12-4-25 AA

SITE PLAN FOR BUILDING PERMIT

PR-2019-2677

PROJECT TITLE
CARLISLE CROSSING
2100 CARLISLE BLVD N.E.
ALBUQUERQUE, NEW MEXICO

# SITE WORK PHASE PLAN

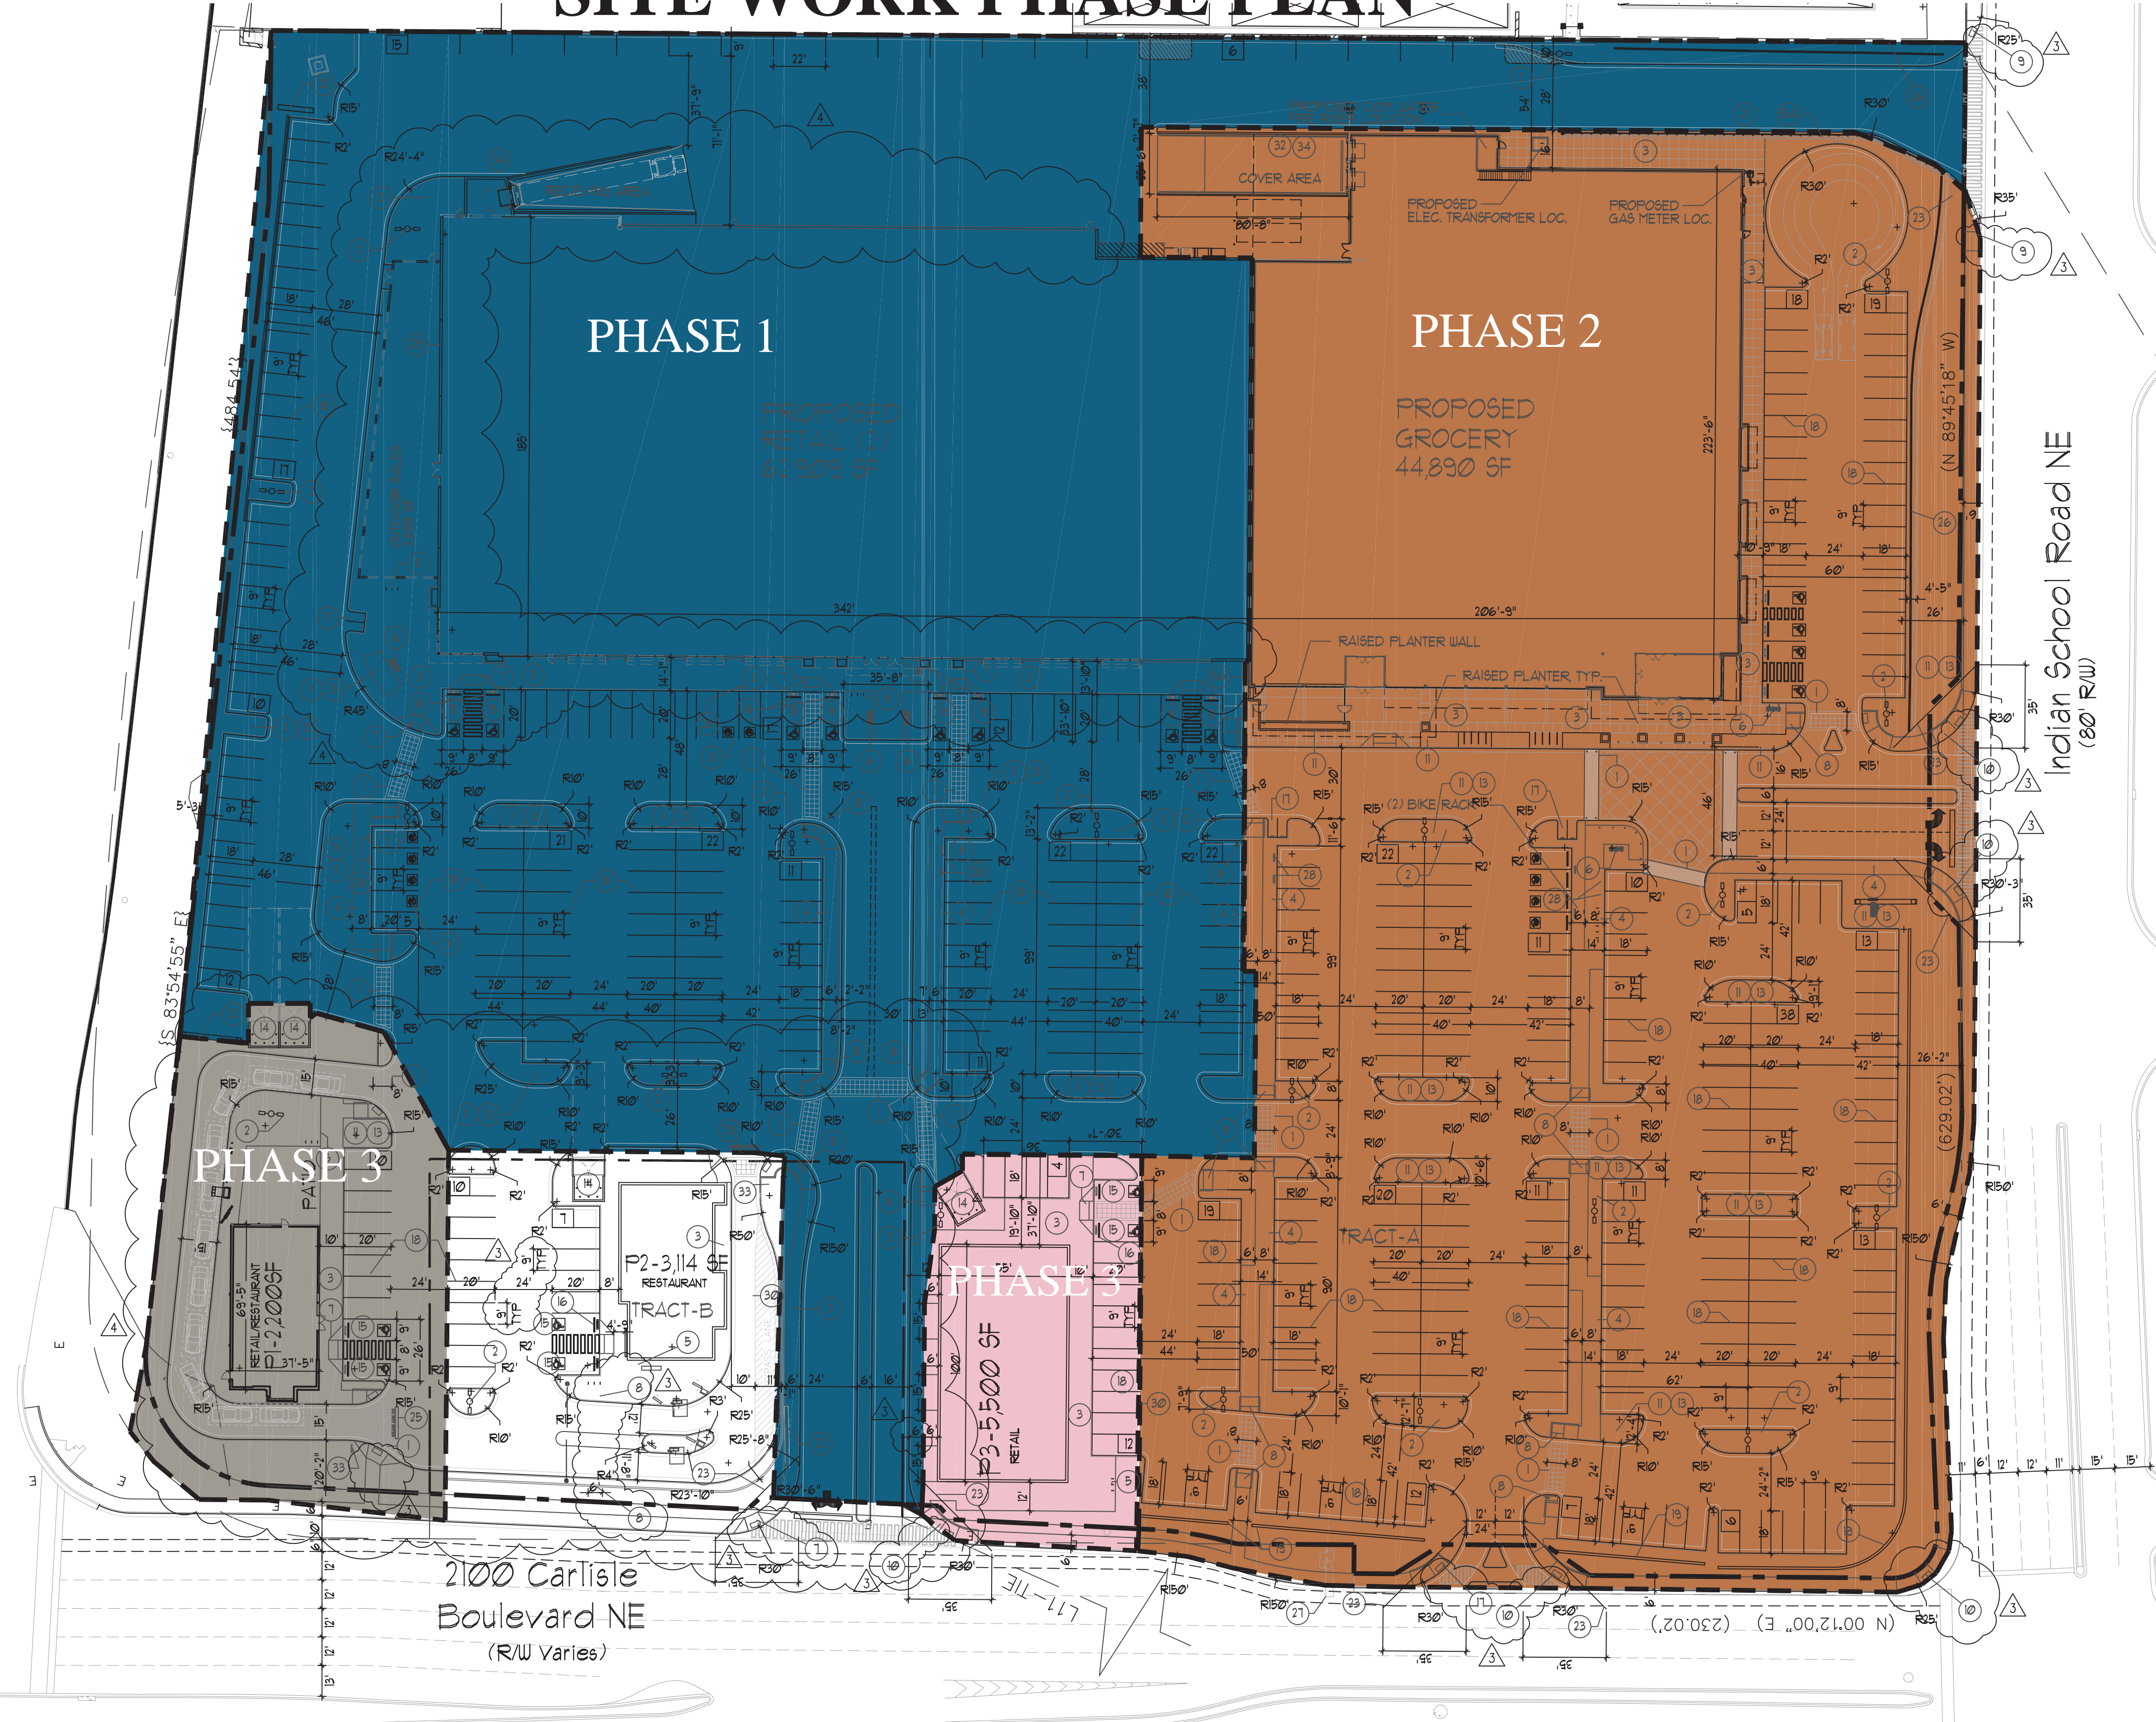
Ms bikes
New hand pump
curved full weather
car-st
short

Att 6 bike space

1. add 6 bike
2. down - both possible paths
3. more corners in down
